Application No: WA/93/20/PL
Site Address: Land East of Tye Lane Walberton BN18 0LU
Description of works: Alternative vehicular access off Tye Lane & emergency access off Avisford Park Road, along with minor highway works following WA/95/18/RES. This site is in CIL Zone 2 (Zero Rated) as other development.

Thank you for your internet representation made on 13th May 2021 which has been recorded as an objection with the comments as follows:

Appendix B
Traffic Flow Diagrams

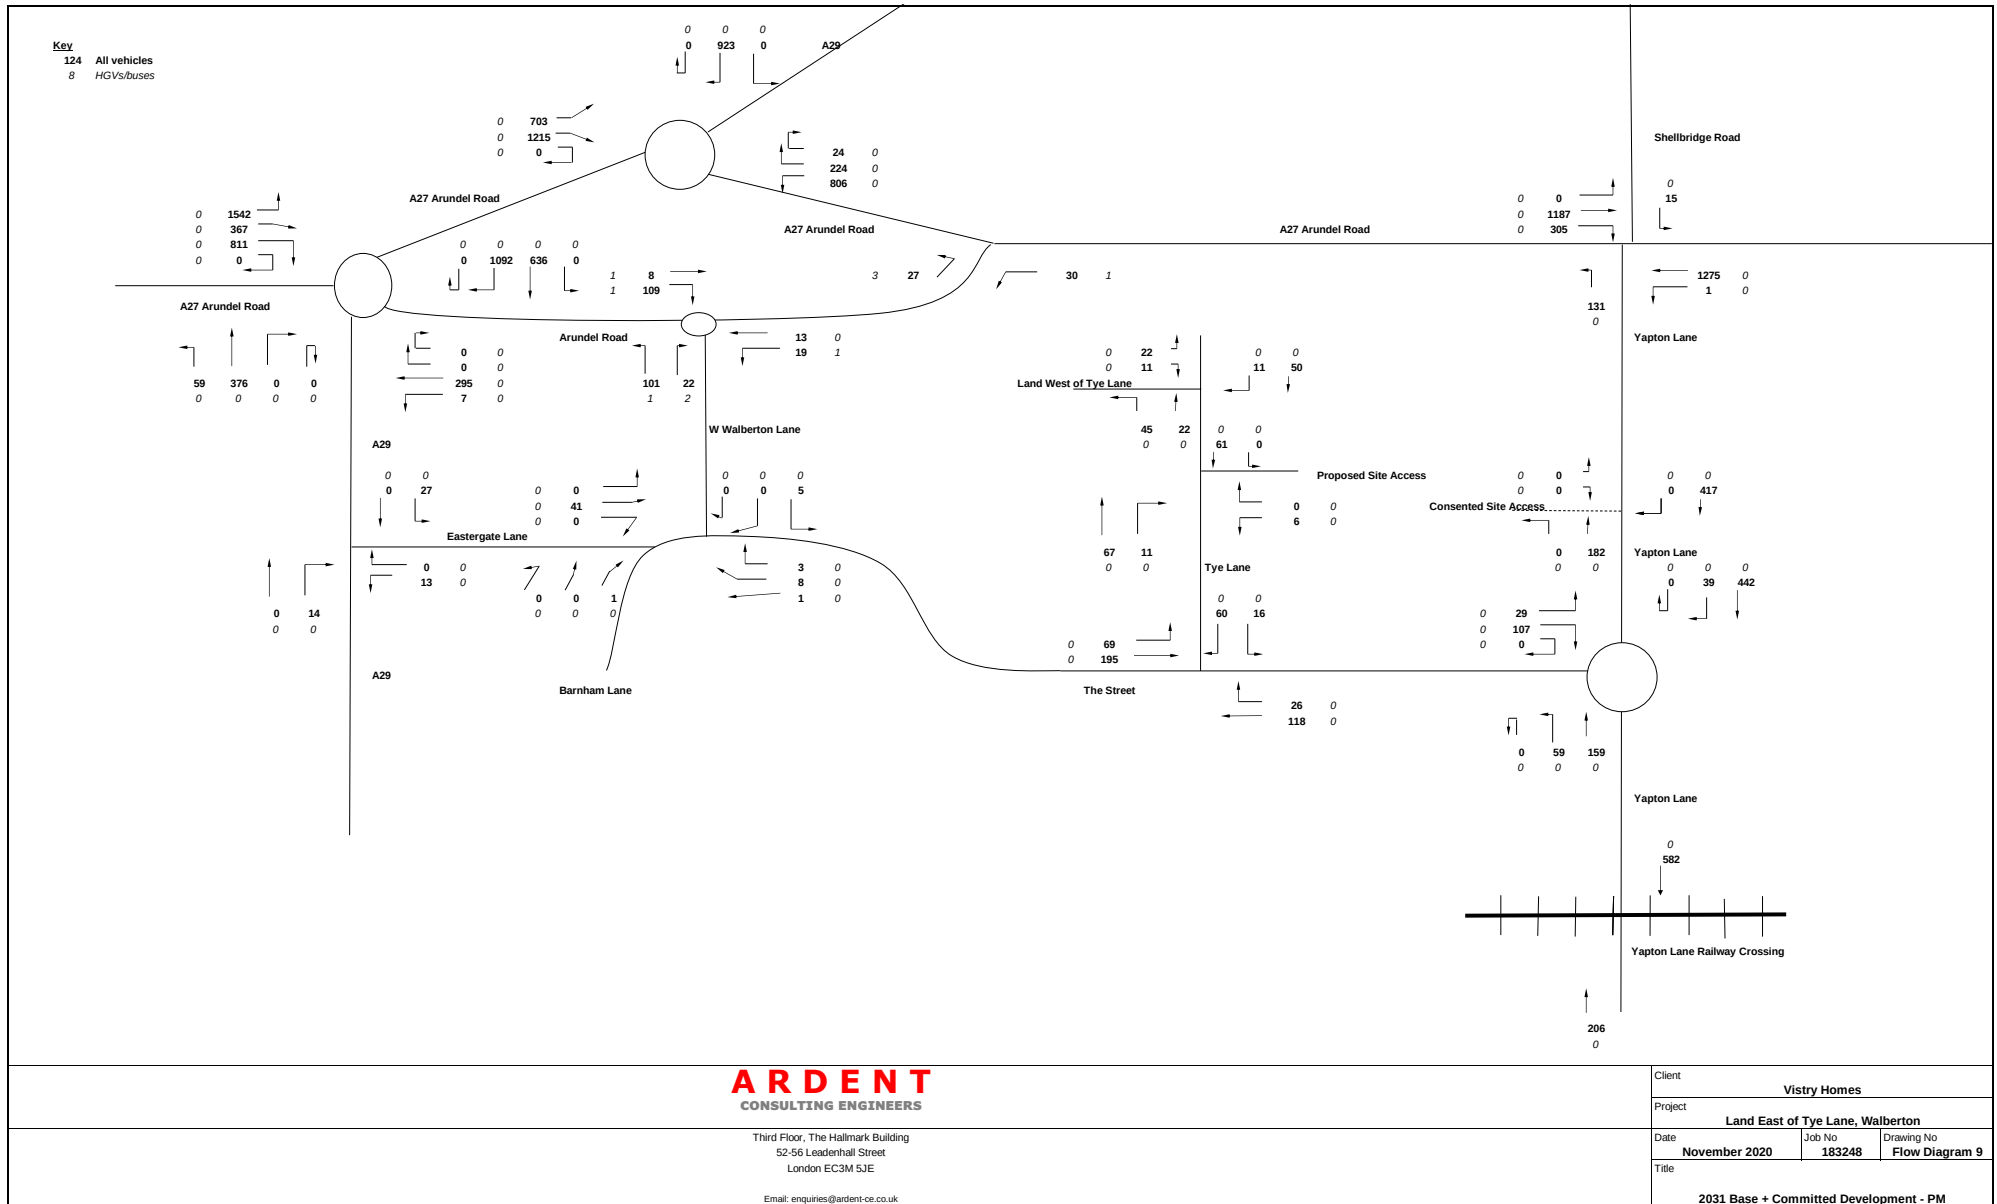
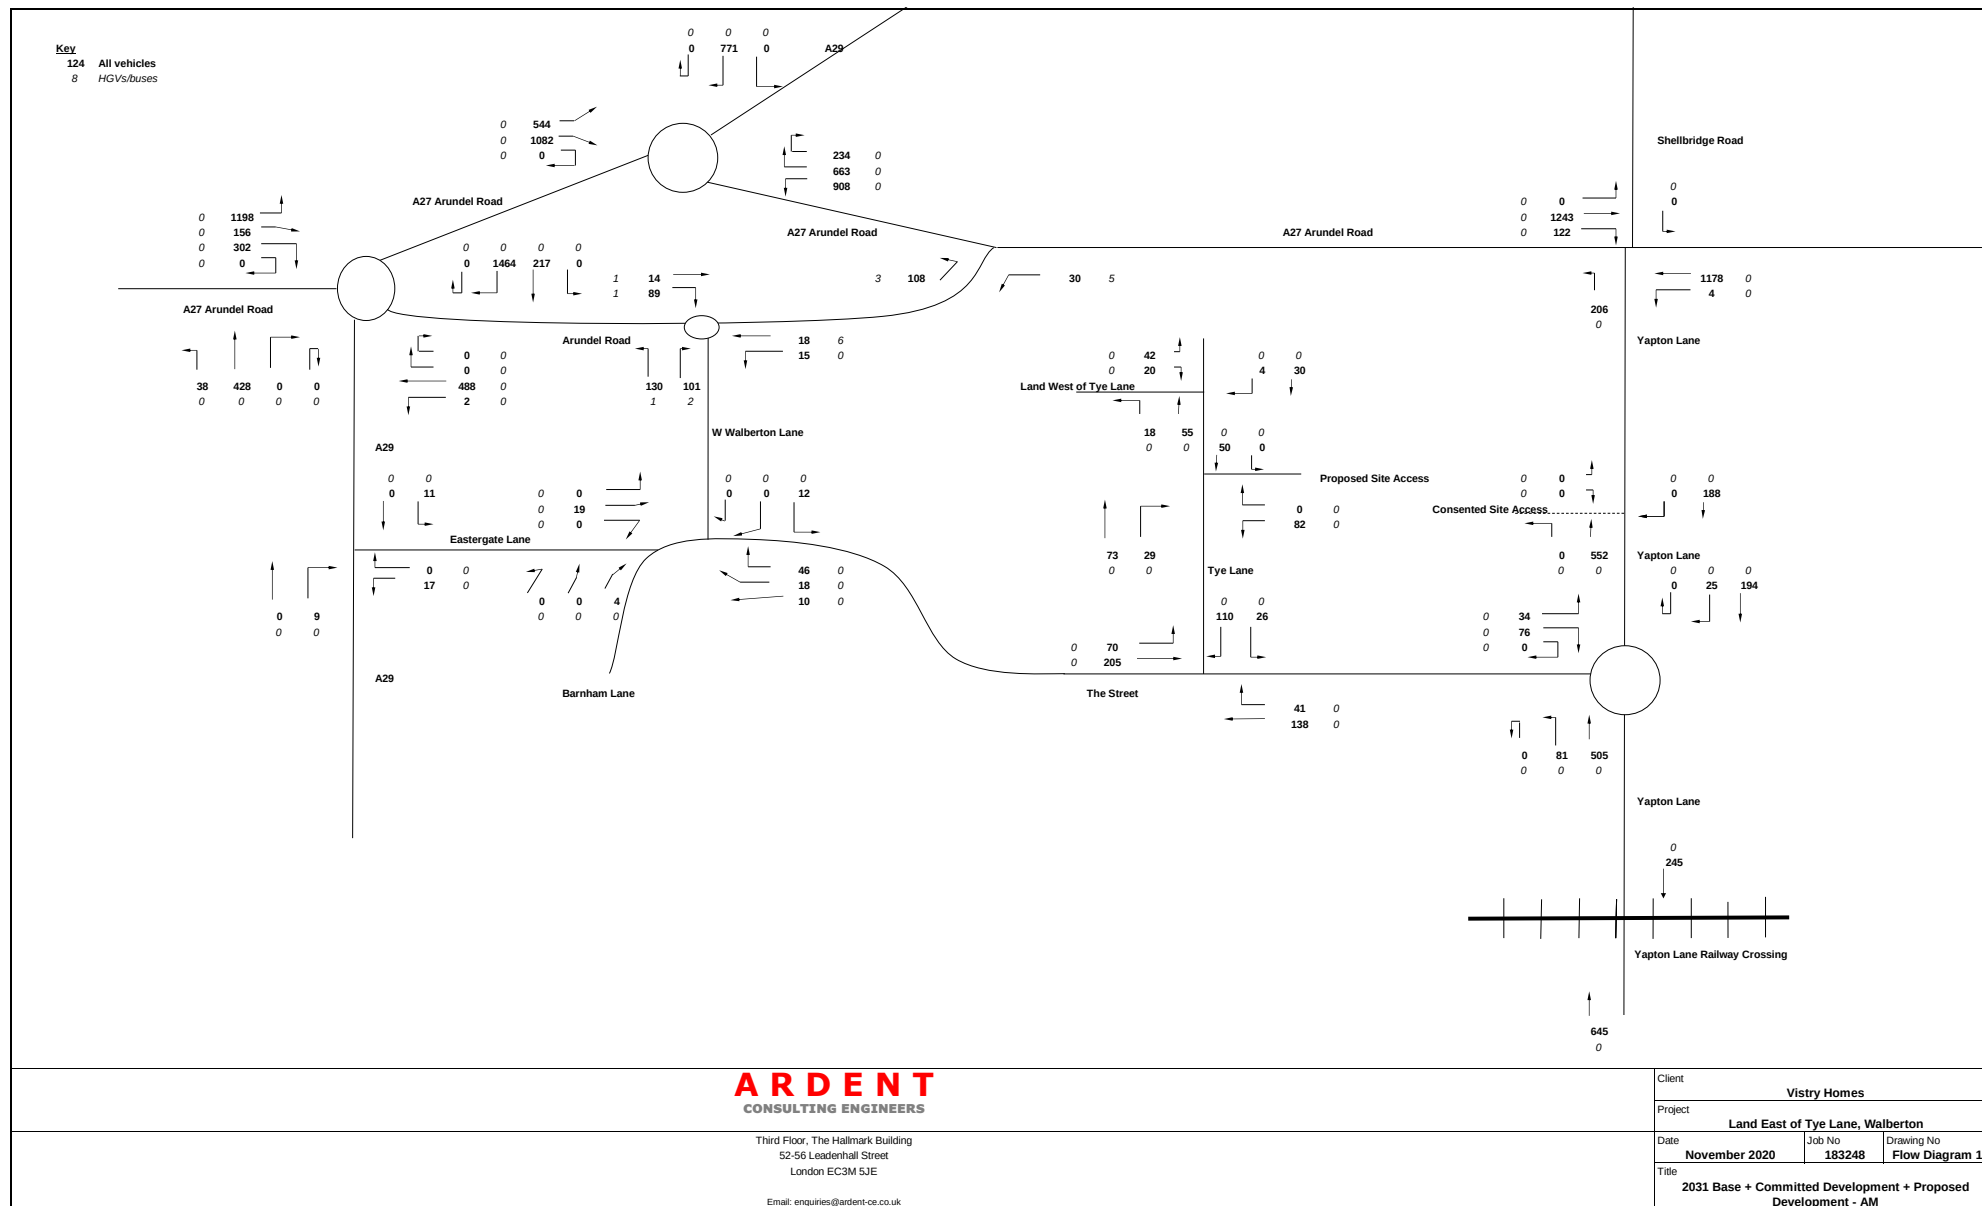
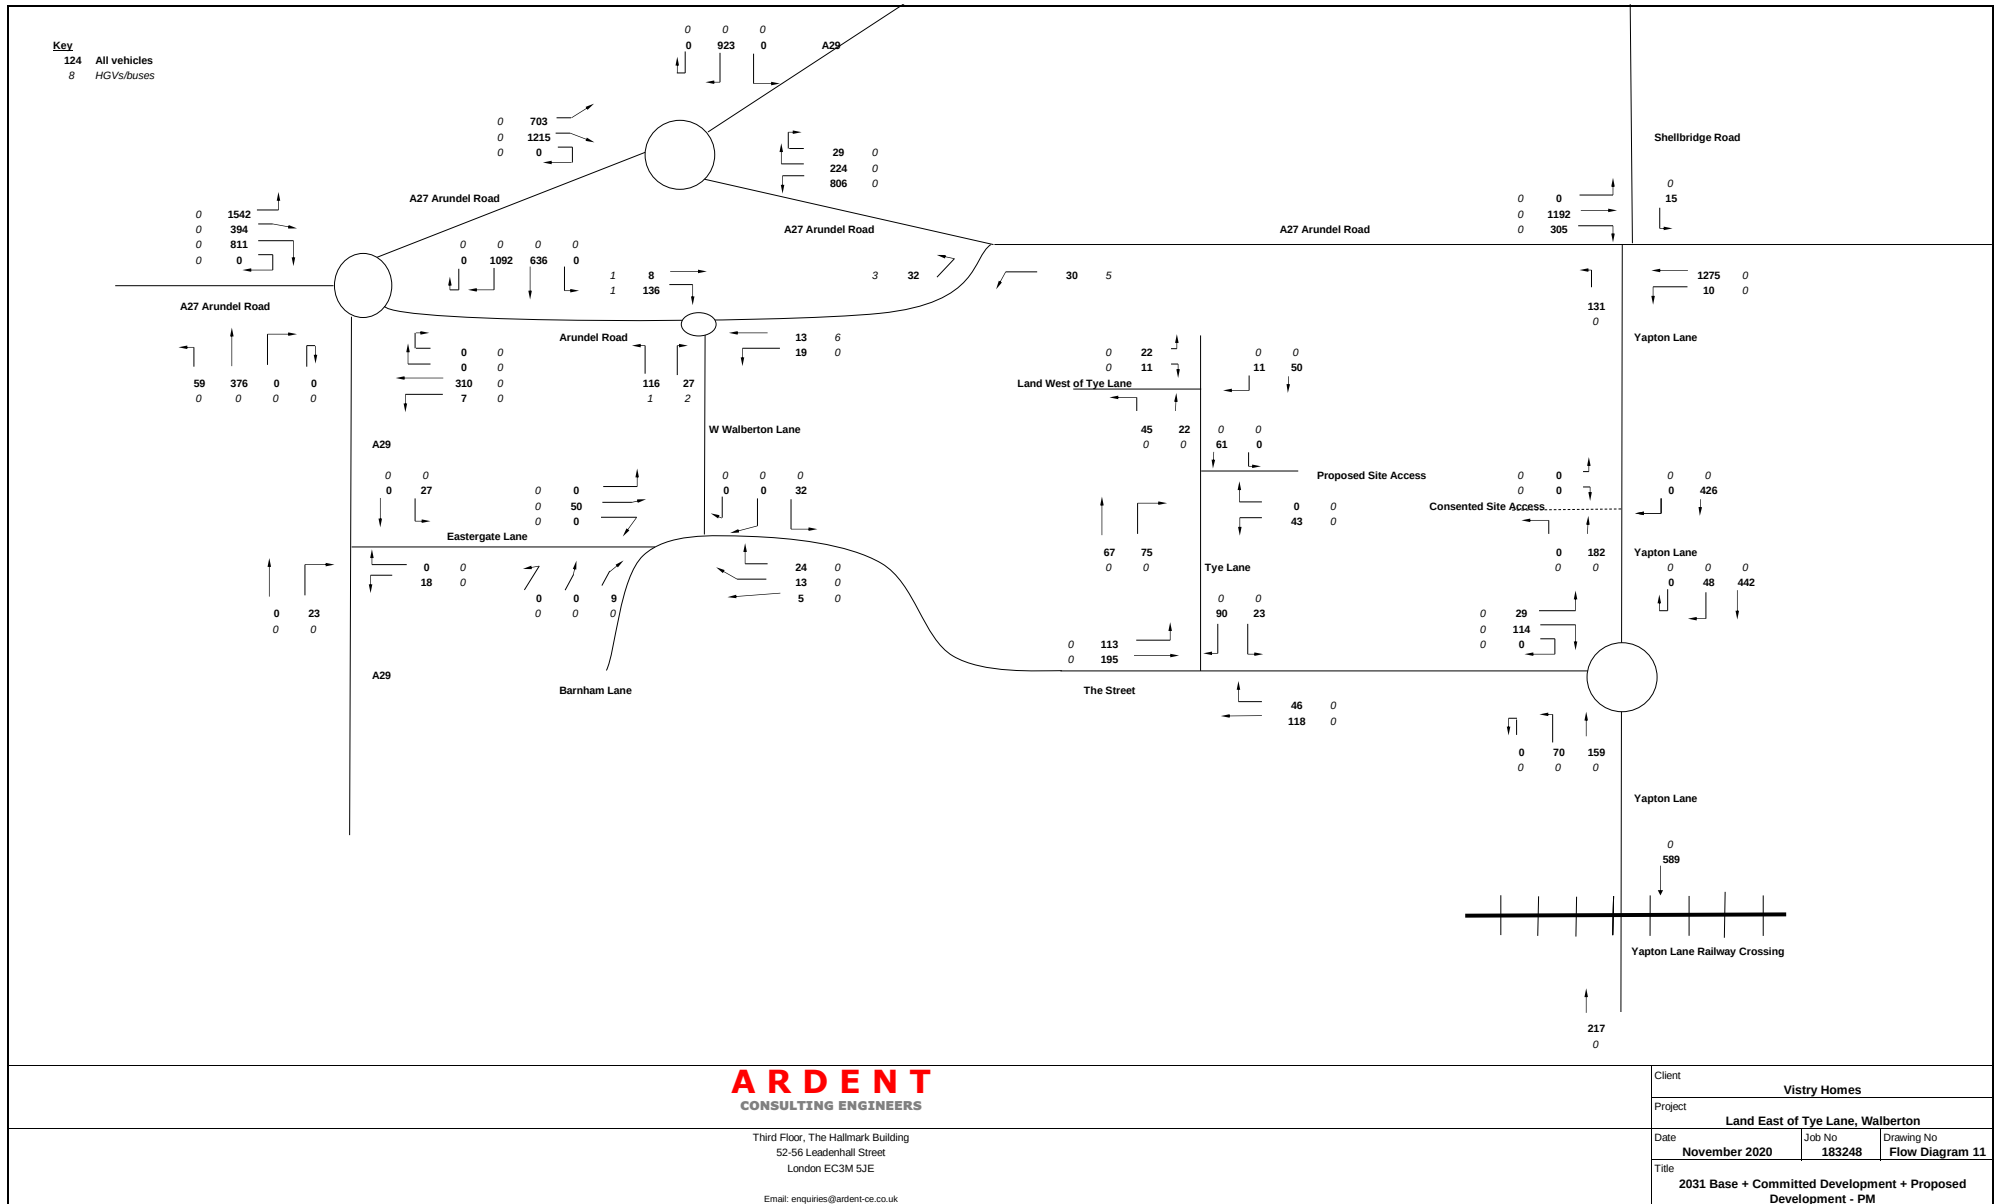
The Traffic Flow Diagrams would appear to be based on national figures rather than a small village. The bus schedules presented is misleading - there are in total only 3 services per day on the 66A route Monday to Saturday and 5 on the 85 route Monday to Friday only.

The 2011 census indicates that this Parish has almost double the West Sussex average for 3 and 4 car households and a third more than the 2 car household. The conclusion is that more traffic than described in the flow diagrams will be using local roads unsuitable for this level of traffic. An increase in traffic will result in increased local air and noise pollution as well as increased problems related to existing flooding on the roads around the Village Green and the Pond affecting several properties.
